My comments relate to my three remaining concerns as a registered Interested Party. I am replying to comments made by the Applicant in REP3-025.

RR-095a

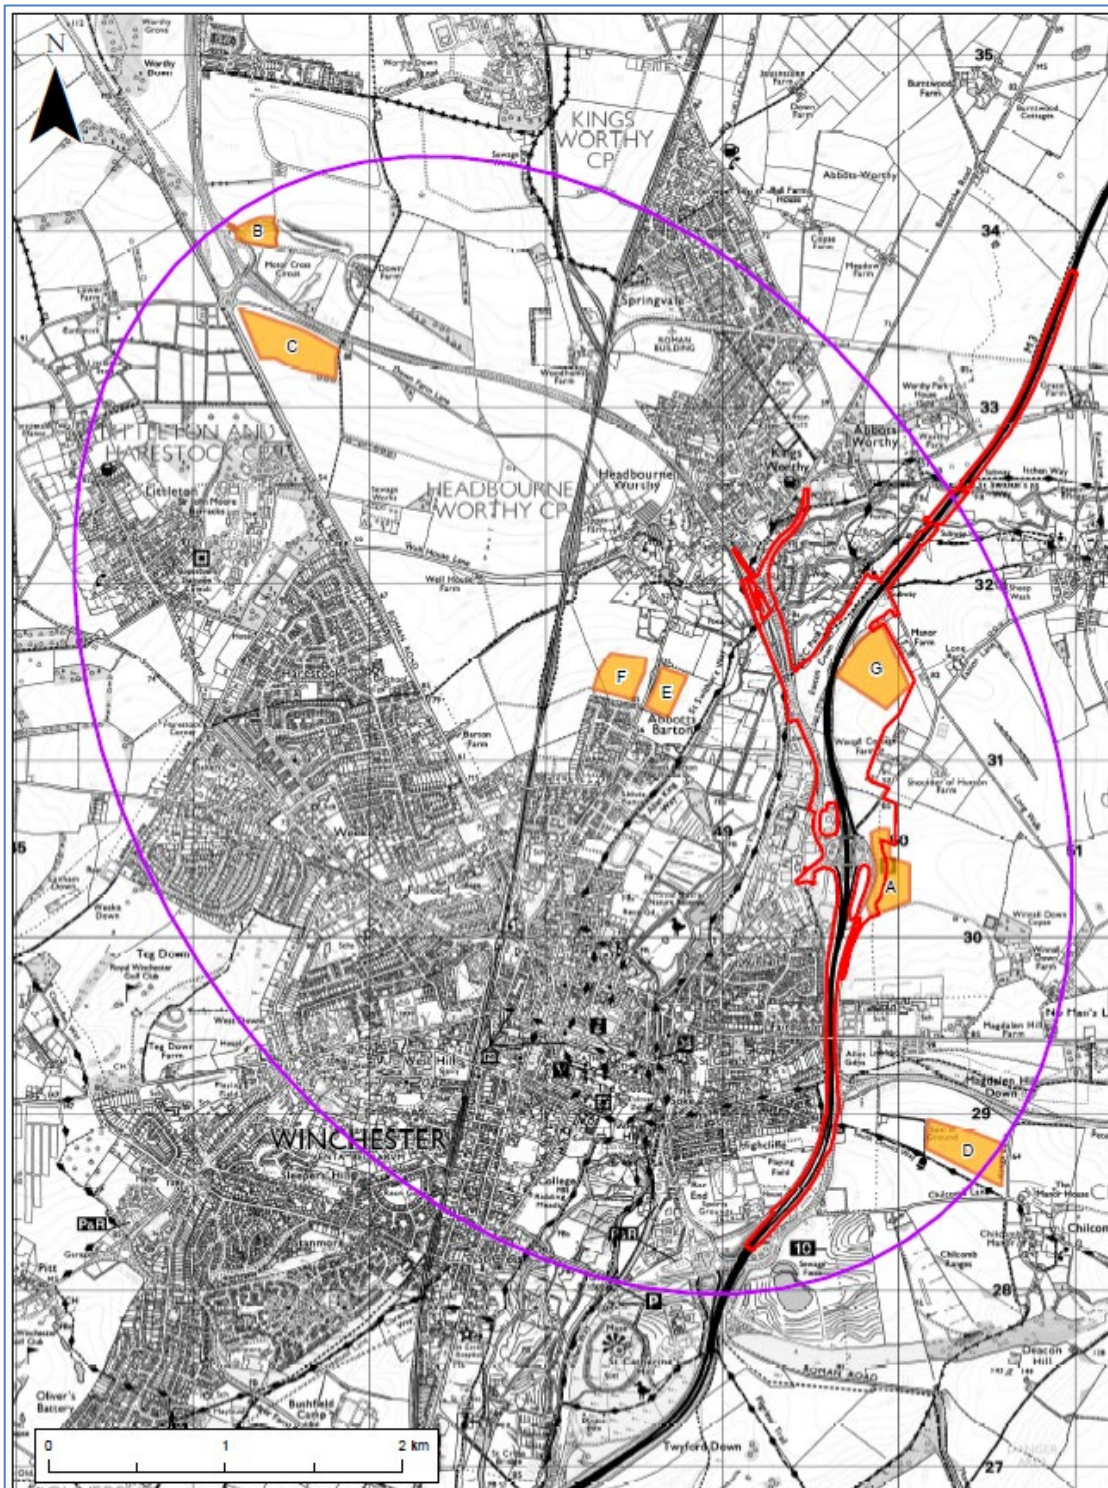
I don't believe I have been given a complete answer to my questions about the R&W Environmental Yard being a reasonable alternative to taking additional land from within the SDNP to provide construction compound areas. Given the R&W yard is either likely already in the Applicant's ownership (I did ask for this clarification at D2 but a response was not provided) or at least entirely within the bounds of the Applicant's existing soft estate, it is nearer the proposed construction site than the proposed construction compounds in the SDNP providing both the opportunity to reduce new land take and reduce construction vehicle trips. Therefore I argue it is a reasonable alternative regardless of ongoing operations matters. The fact a previous response from the Applicant noted the R&W yard was "deemed not to be a viable option" suggests it was considered and therefore should have been reported in the Alternatives chapter of the Environmental Statement. As an alternative in that chapter, the assessment of the environmental beneficial effects of this land parcel providing c.50% of the required construction compound area to the east of the site would be known and inform this line of comment.

Q. Will the Applicant give consideration to reducing land take in the SDNP and if not provide full justification why not.

(Incidentally, I could make no sense of the latter part of the response at D3 regarding left only turns from the proposed construction compound exit - I still maintain use of the R&W yard as an alternative to the furthest reaches of the proposed compounds will significantly reduce construction haulage).
